Engineers Comments Regarding Surface Water Drainage

Application Reference:	AL/4/26/DOC	Reviewer Reference:	ADC/EXT5/AF
Planning Officer:	Hebe Smith	Date of Review:	16/02/2026
Site Name:	Stanwick Northfields Lane Westergate PO20 3UH		
Application Description:	Approval of details reserved by condition imposed under AL/70/24/HH relating to condition 3-surface water drainage.		
Assessment Number:	1

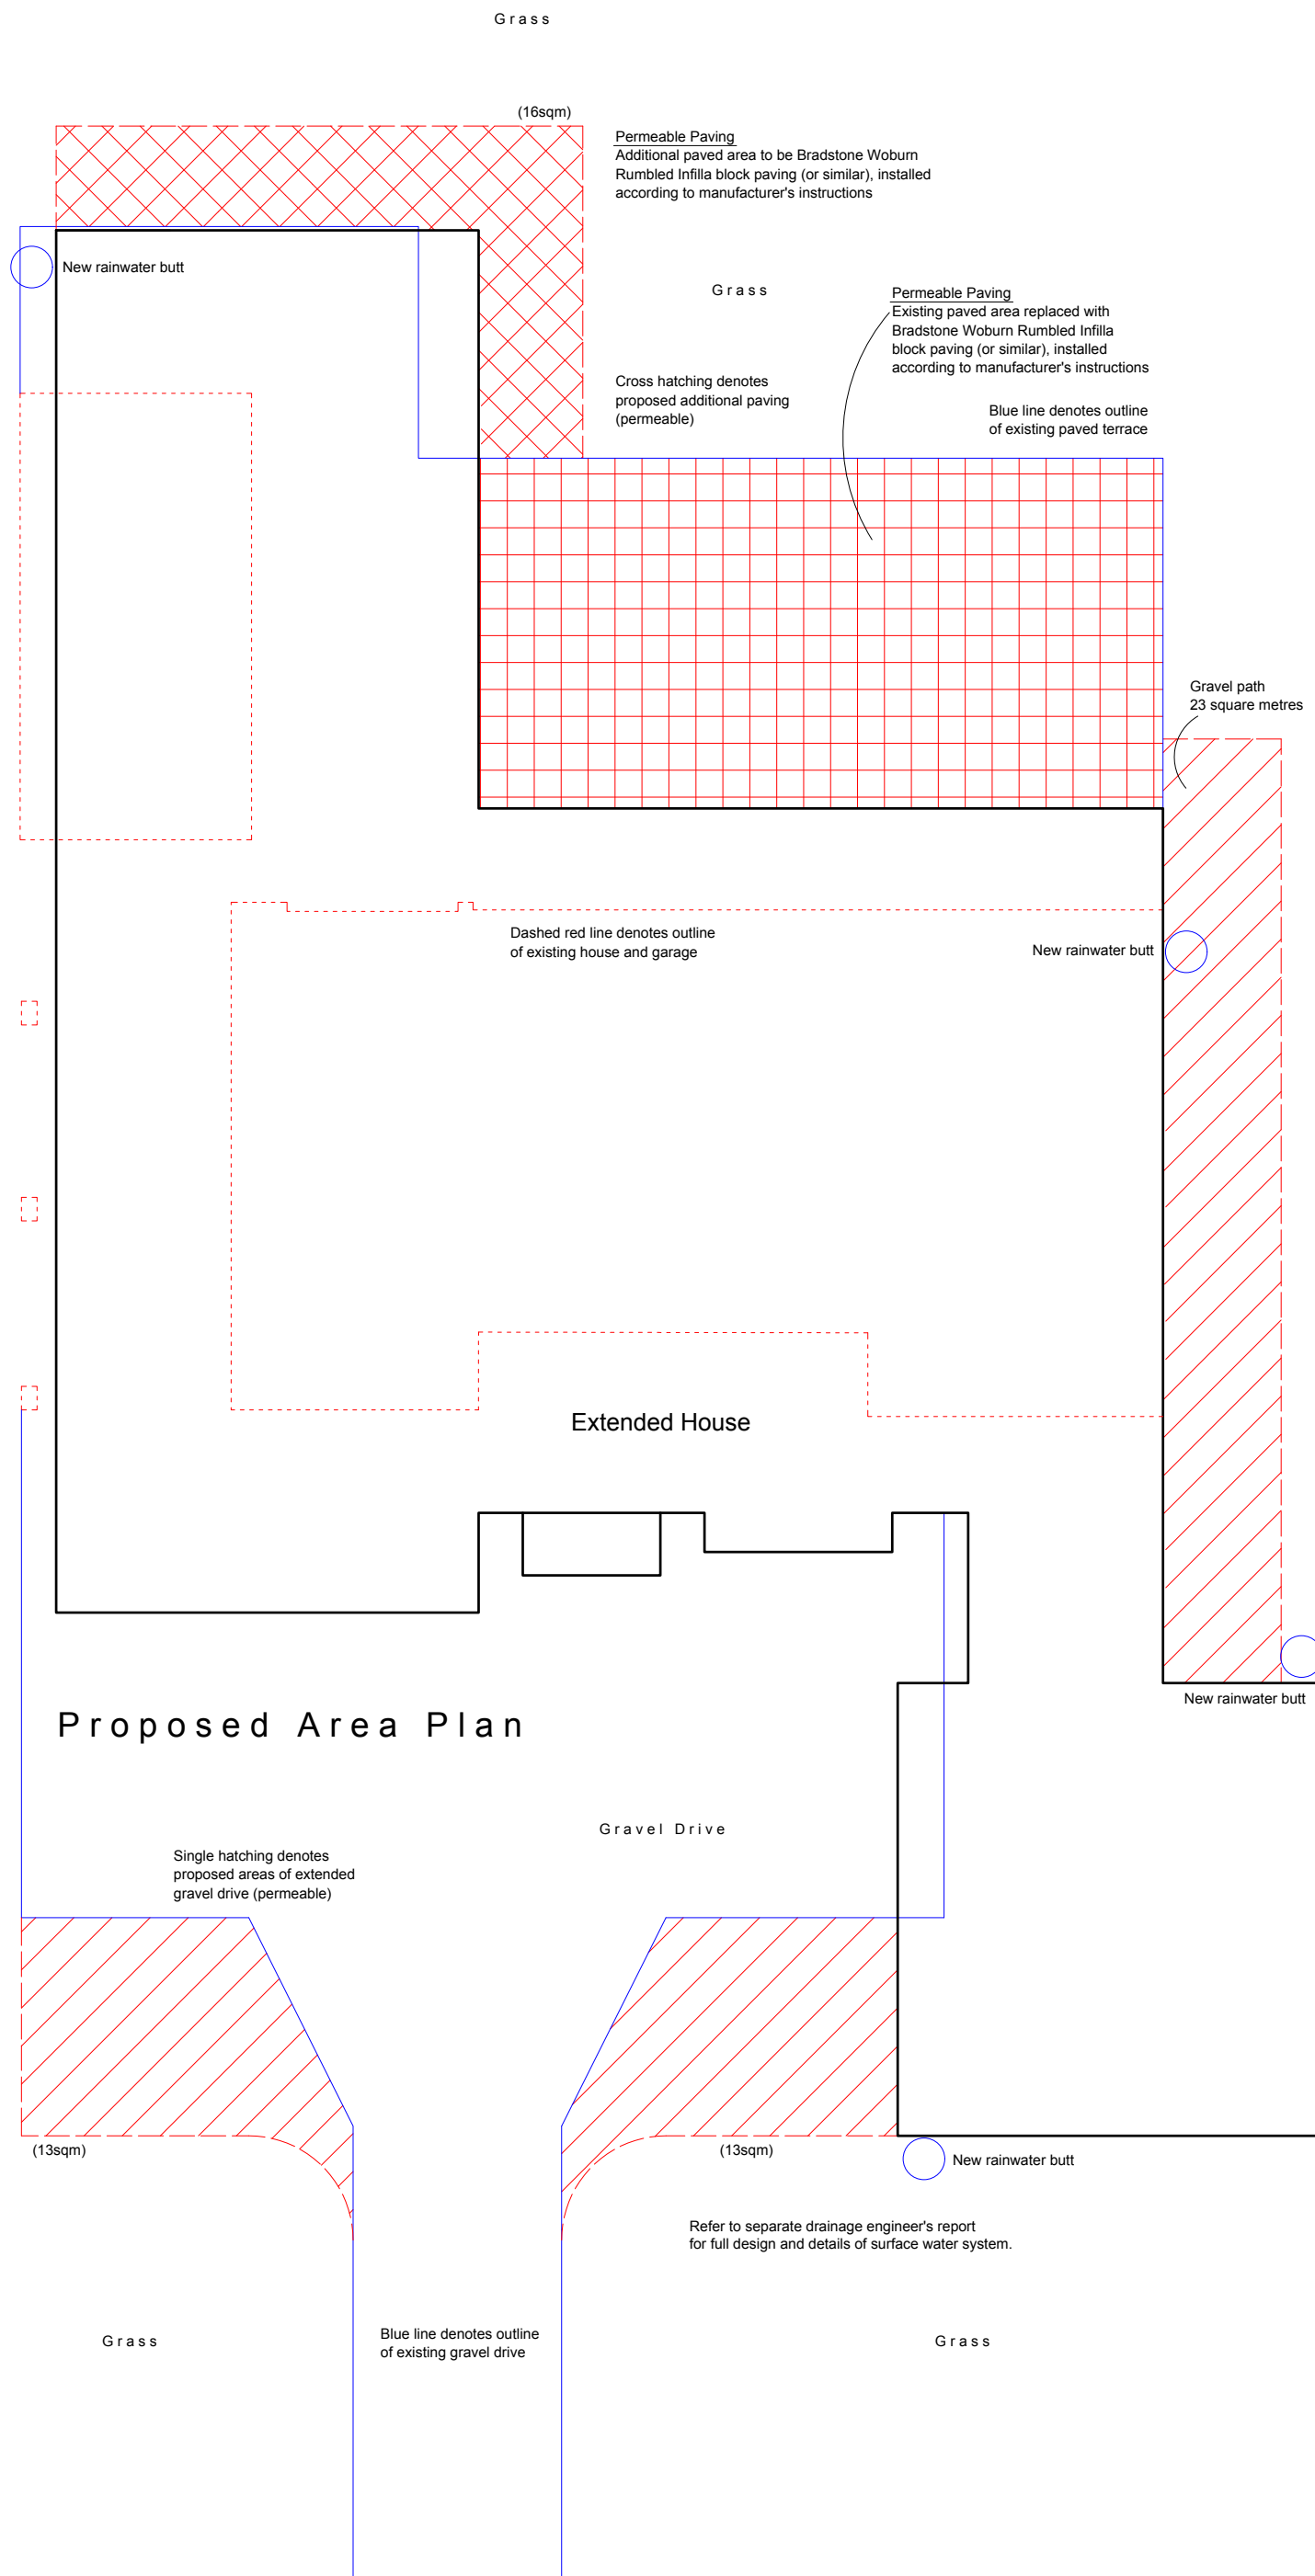
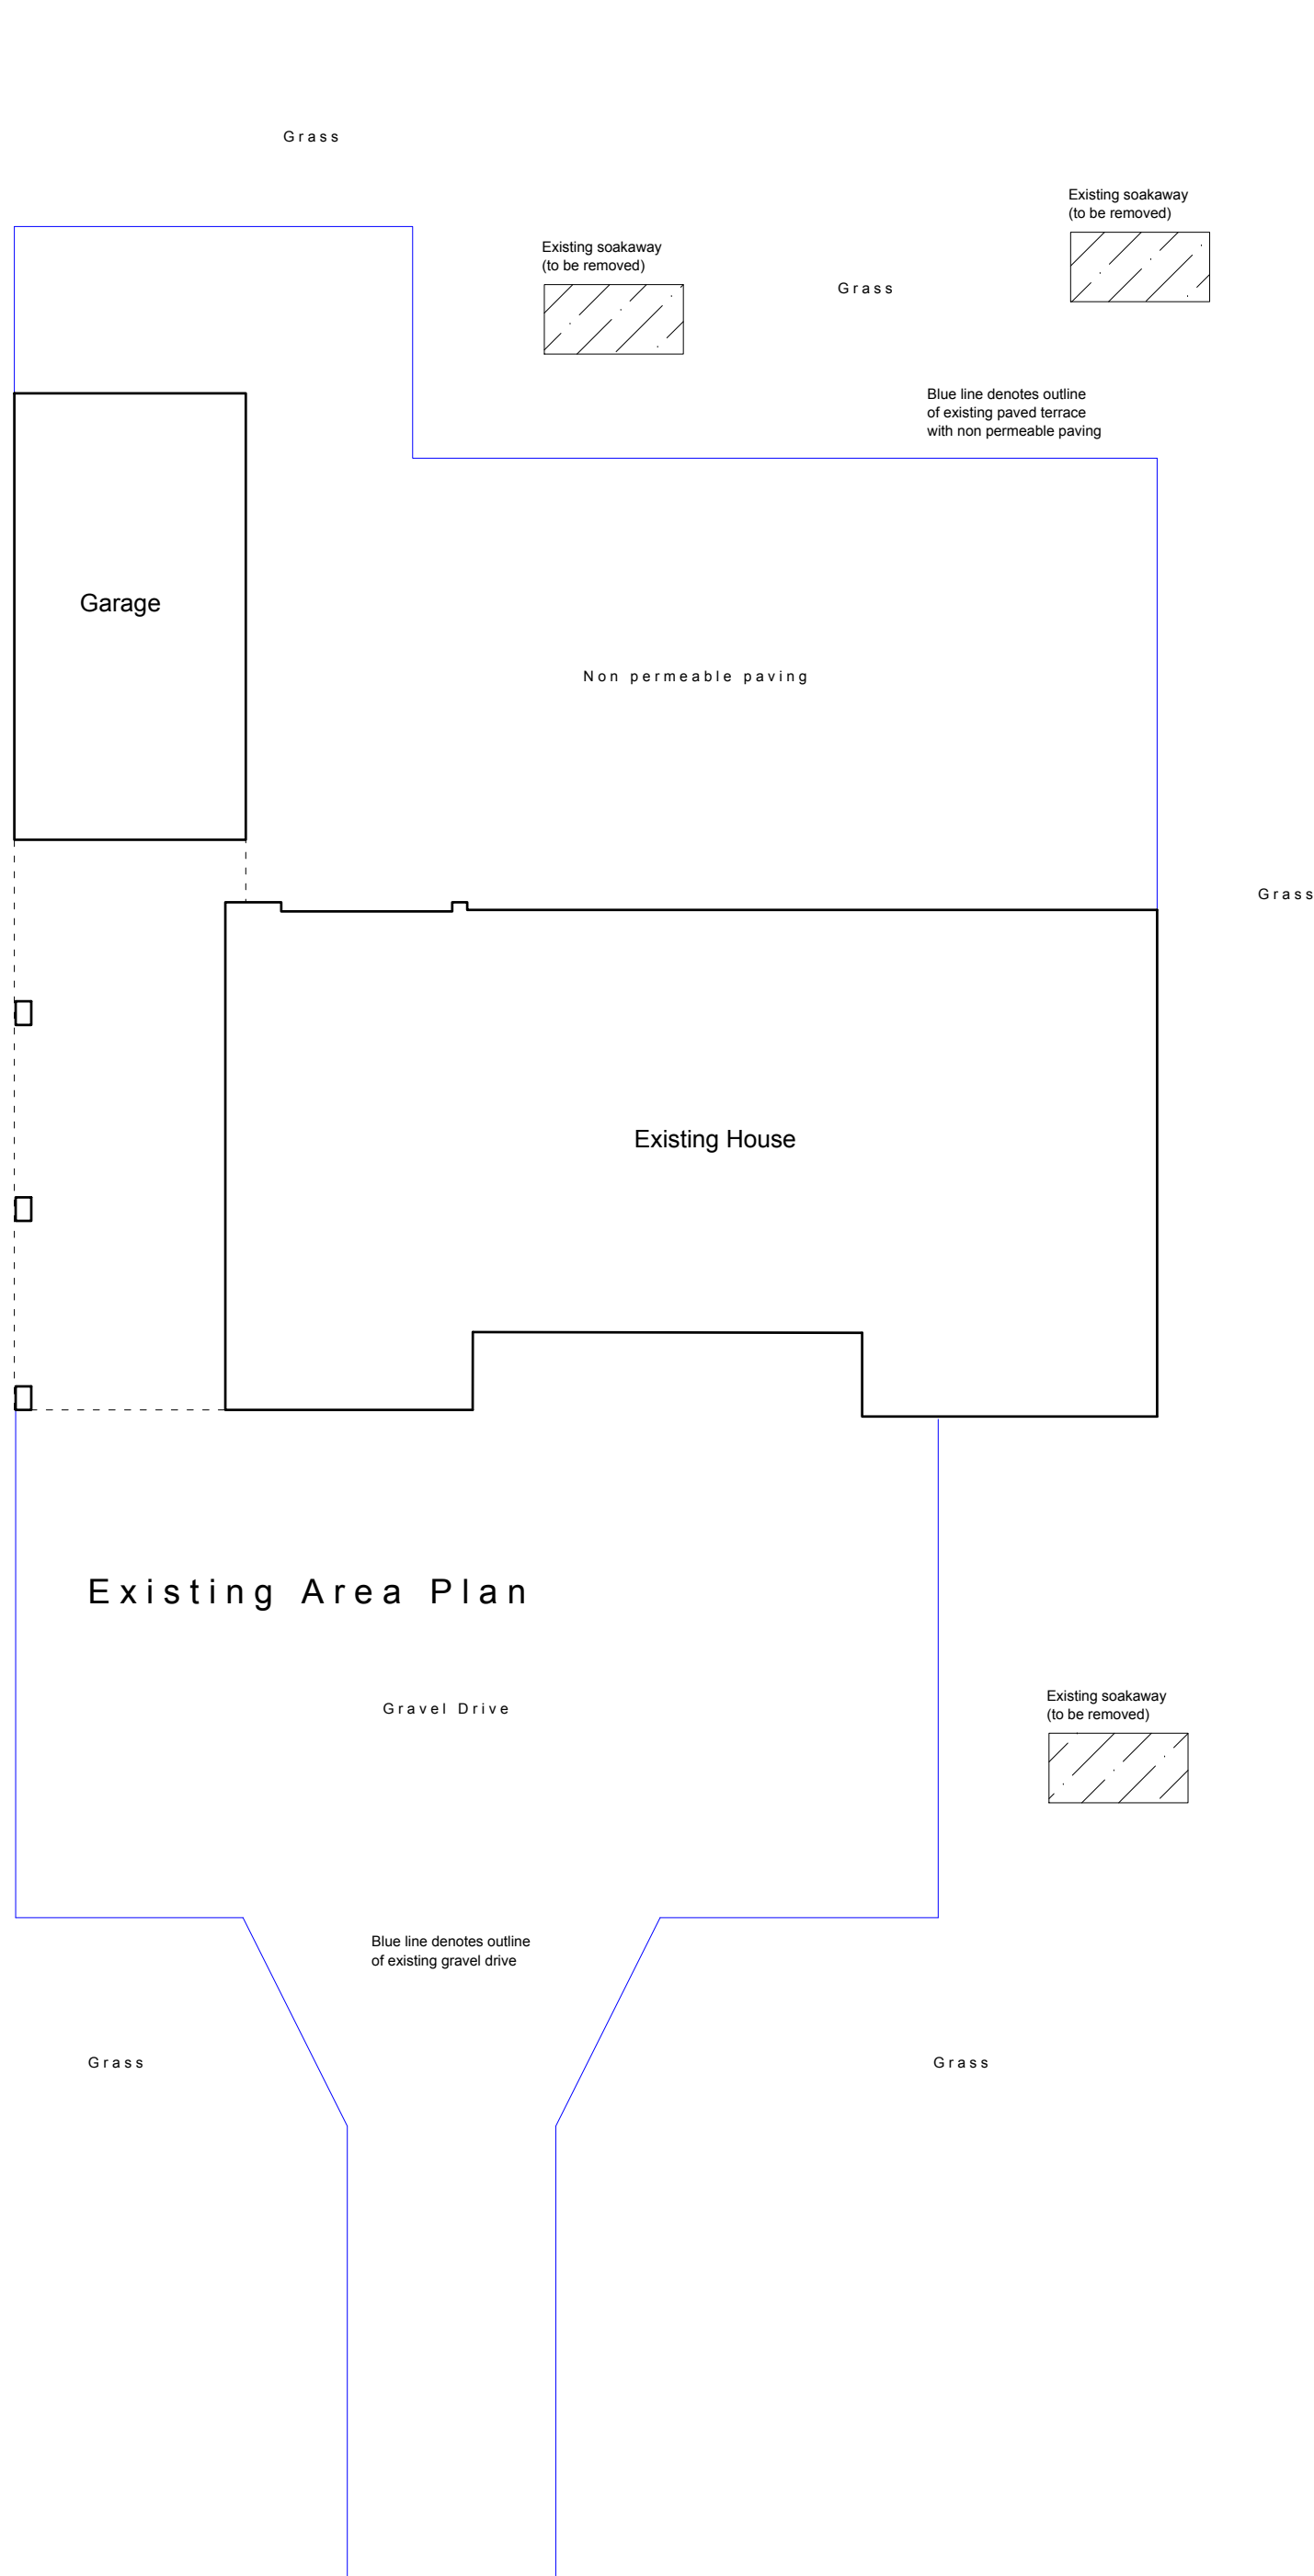
ADC Drainage Comments	ADC Drainage Comments			
Date:	21/10/2024(AL/107/24/DOC)	16/02/2026			
Condition Number: 3					
Comment Number					
1.	Rainwater reuse must be proposed where possible in accordance with the hierarchy for sustainable drainage. Water butts are an effective way of achieving water reuse and interception drainage.	Water butts are included in the revised design and are acceptable for the type and scale of development. Comment closed.
